Pls add below email to file and label as 'Suggested pre-commencement planning conditions'

I have now drafted my reports for these two applications and they are now with my Manager for finalising ahead of Committee, on 29th July.

PROJECT
ALTERATIONS TO NORTON FARMHOUSE TO FORM SEPARATE DWELLING AND ERECTION OF OAK FRAMED OUTBUILDING
DRAWING TITLE
EXISTING AND PROPOSED ELEVATIONS
SCALE
1/100 at A3
REFERENCE
11913.04

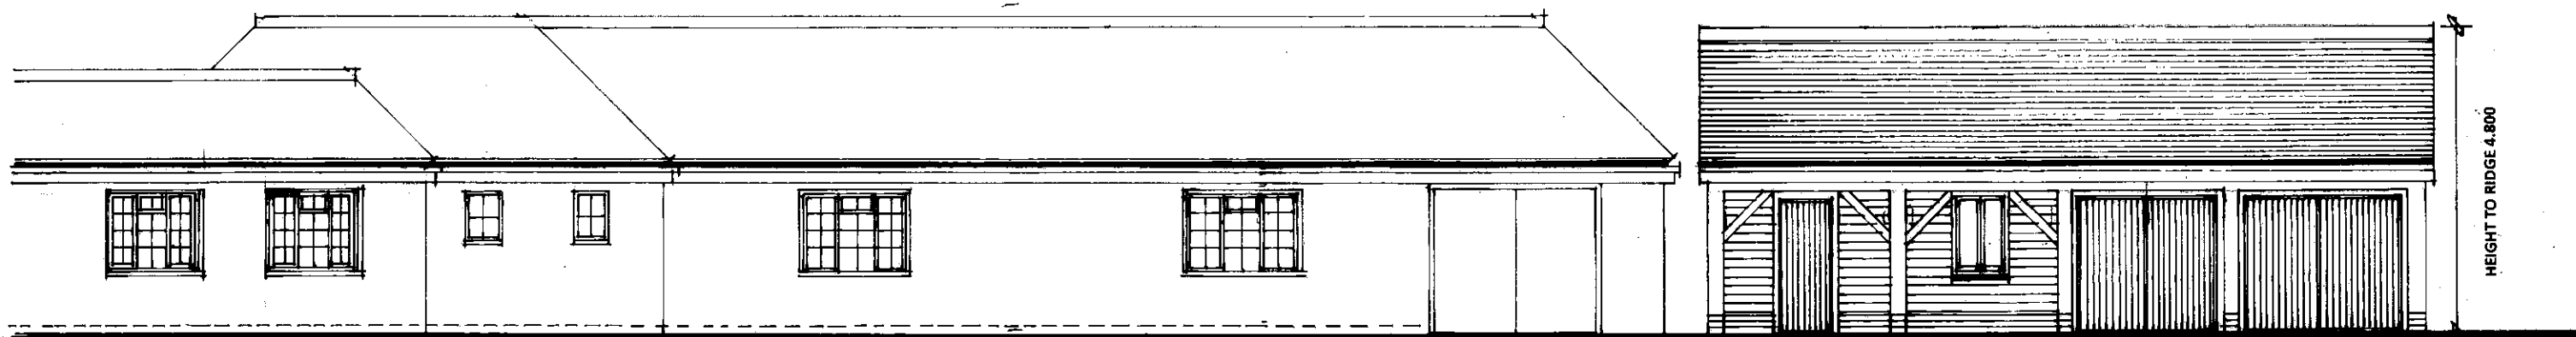
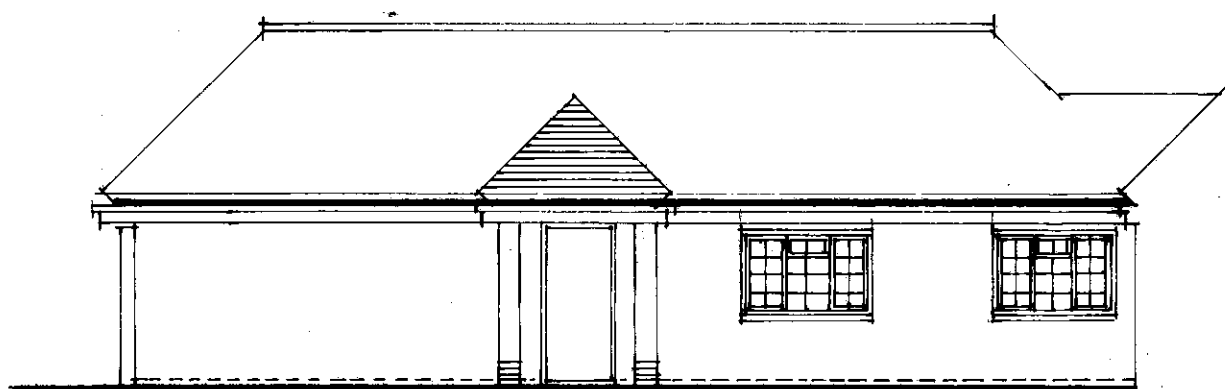
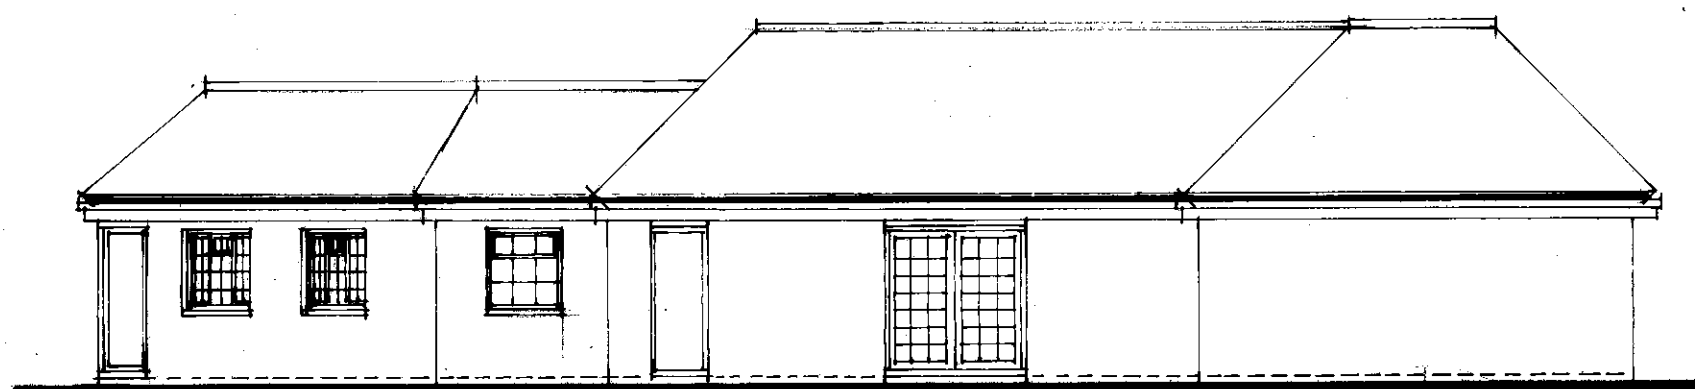
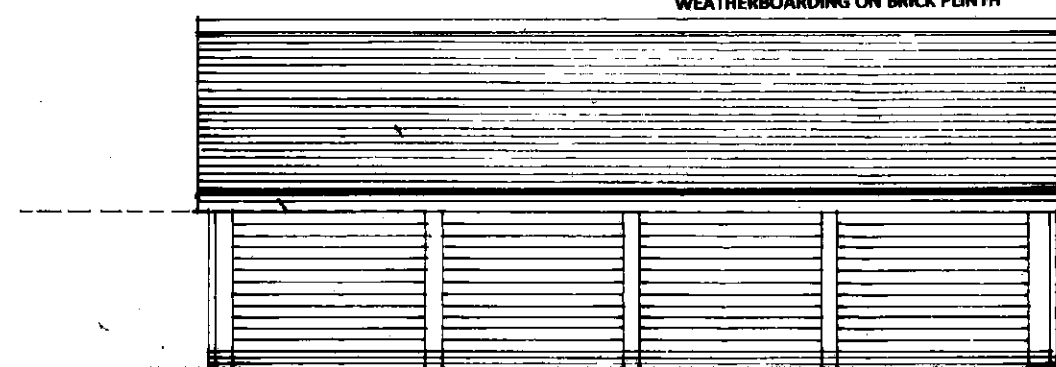
Both myself and the Conservation Officer have picked up on the fact that the East Elevation is not correct – the 2 windows shown do not match the site photos provided – the drawings show 3 bay windows, the photos clearly show single bay windows (and for conservation purposes should stay as such). Please also add annotations to the new entrance door and existing double timber doors to the workshop to state these will be timber (as at the moment they could be seen as glazed). Please also add red bubbles around each of the proposed changes so all is clear. With the existing and proposed all on one sheet at present it is not clear at all.

Please amend the Elevation sheet and send to me by next Tuesday 7th July.
